14 March 2014

Re: SSD 4972 – SECTION 96 MODIFICATION NO.2, FOUR POINTS BY SHERATON  
HOTEL EXPANSION, 161 SUSSEX STREET, SYDNEY.  
REF NO.: SSD 4972 MOD 2

Drawing Title
PUBLIC DOMAIN PLAN GROUND LEVEL

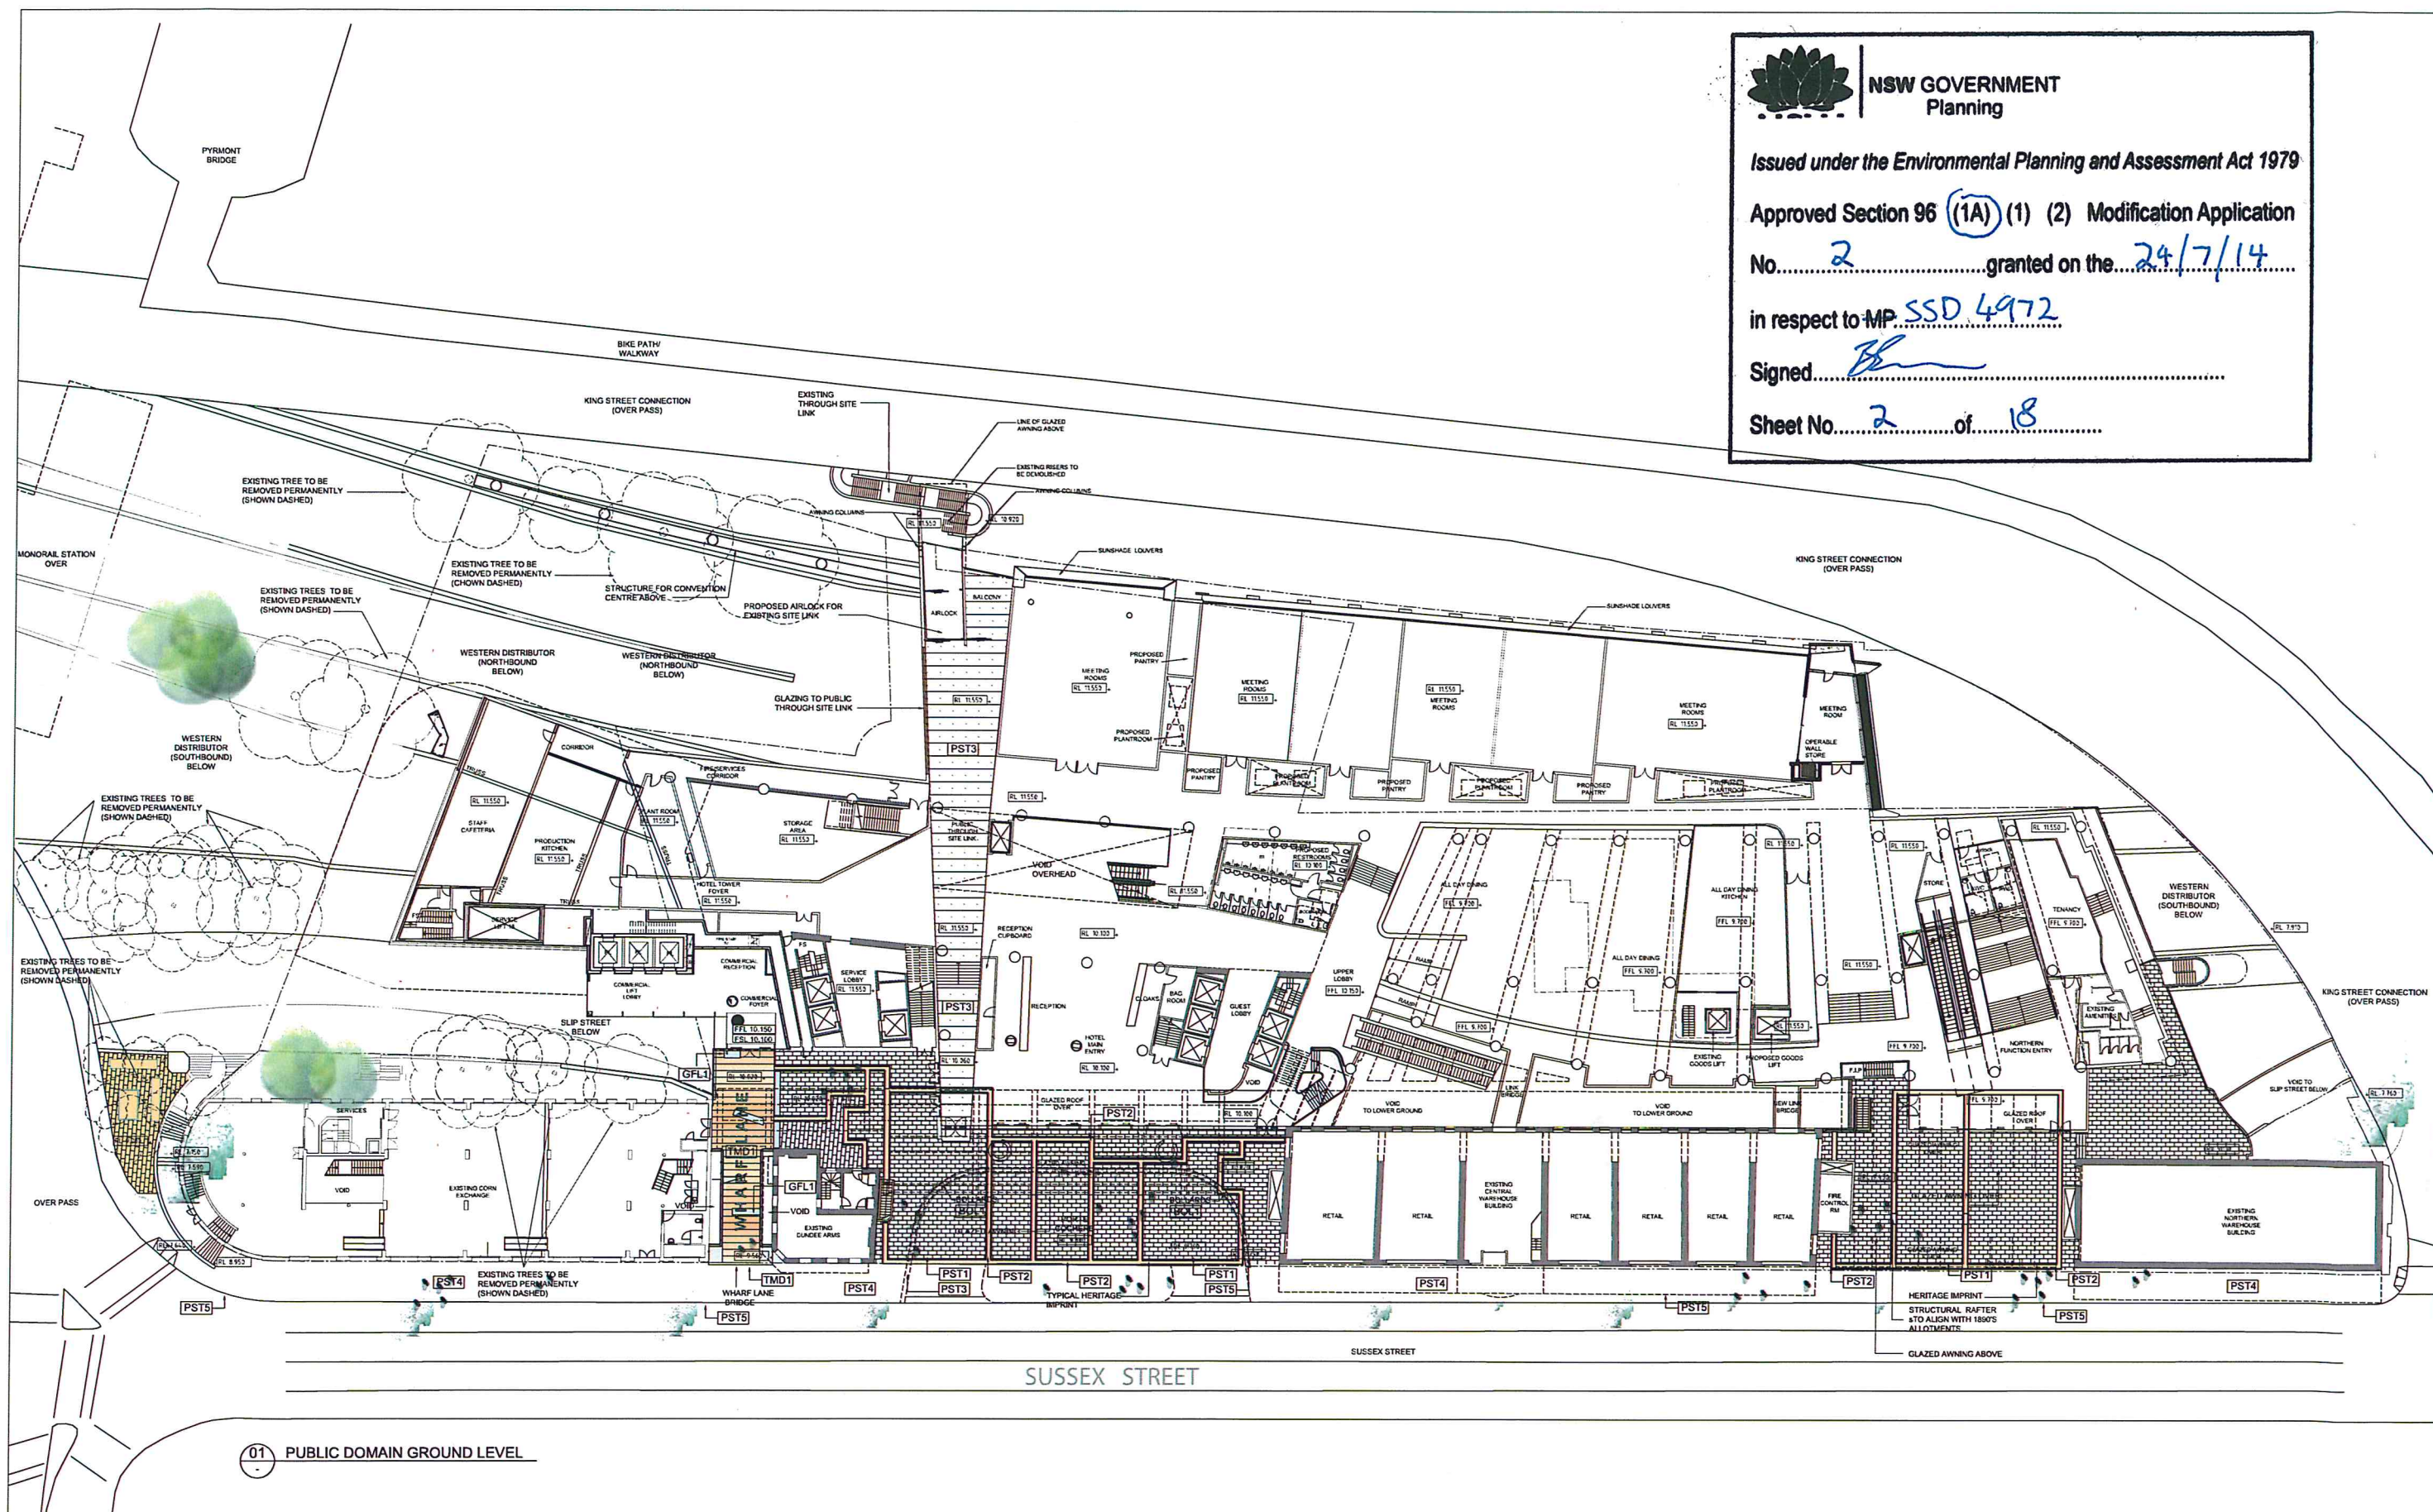
The approved development consisted of a facade treatment, in keeping with the southern part of the conference/function area.

The proposed modification omits design elements which assisted in the articulation of the façade. Finely detailed projections which provided sun protection have been replaced with what appears to be full height glazing panels. This is a departure from the design language adopted for the building. The Authority seeks further clarification in relation to the proposed modification.
